Application no: H13-0161-12

Description: Proposed extension and detached garage

Location: 16 Roman Road
Moulton Chapel
Spalding
PE12 0XQ

Amendment: Amendments showing french doors on floor plan
(dwg. no. WEN/1468/12/01A)

Ref-A	SHOWING FRENCH DOORS ON FLOOR PLAN	MARCH 12
Ref:	Revision:	Date:

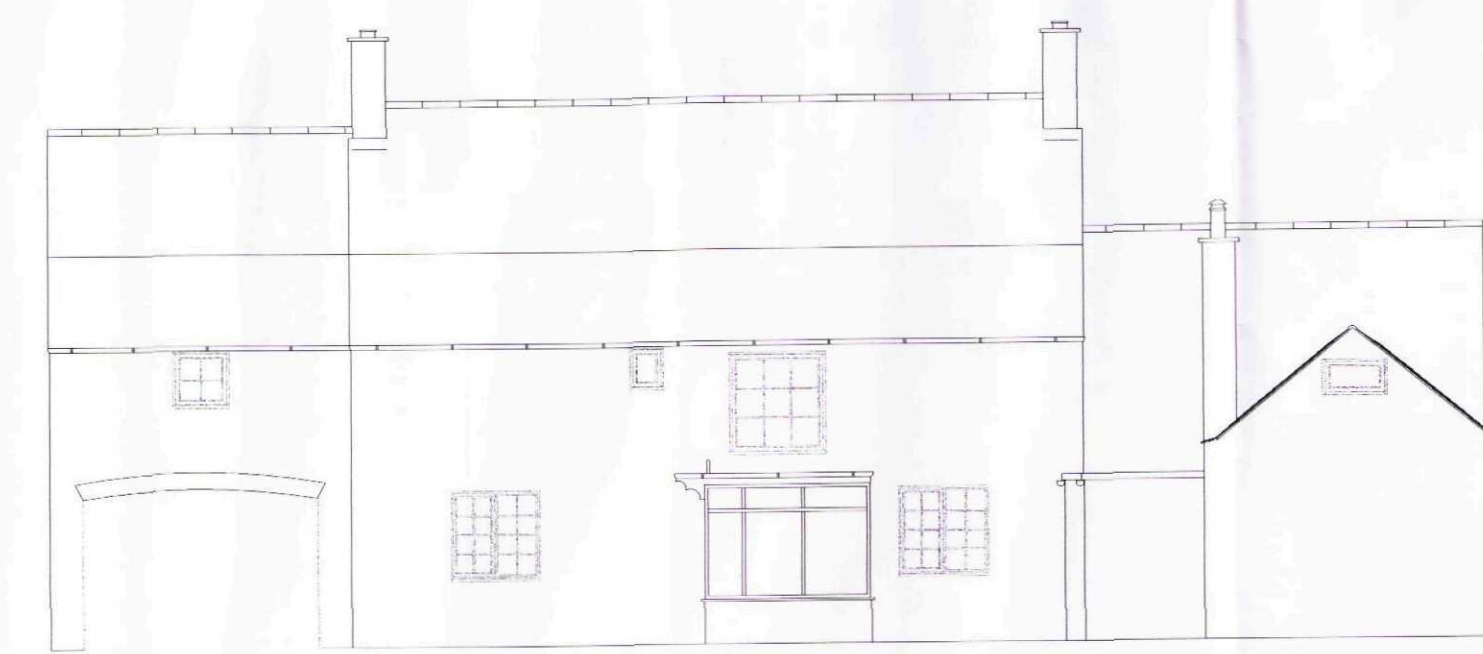
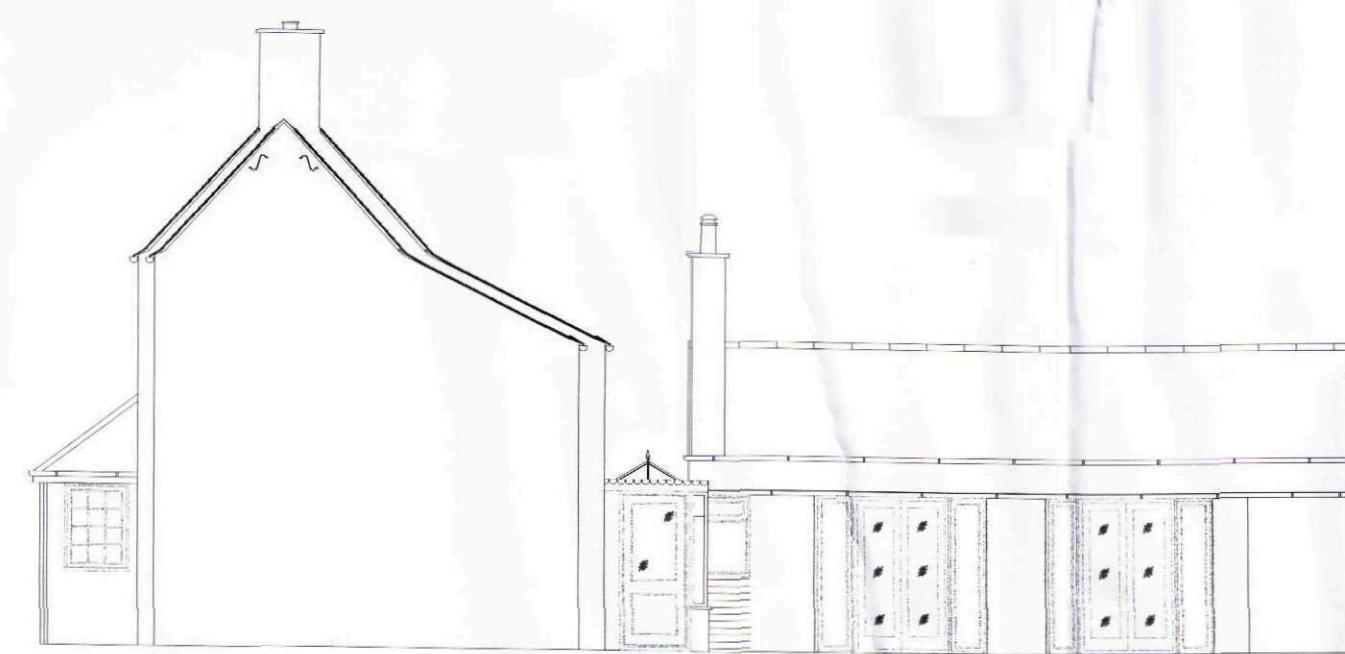
Thank you for your telephone call this morning, please find attached an amended plan showing the French doors on the floor plan.
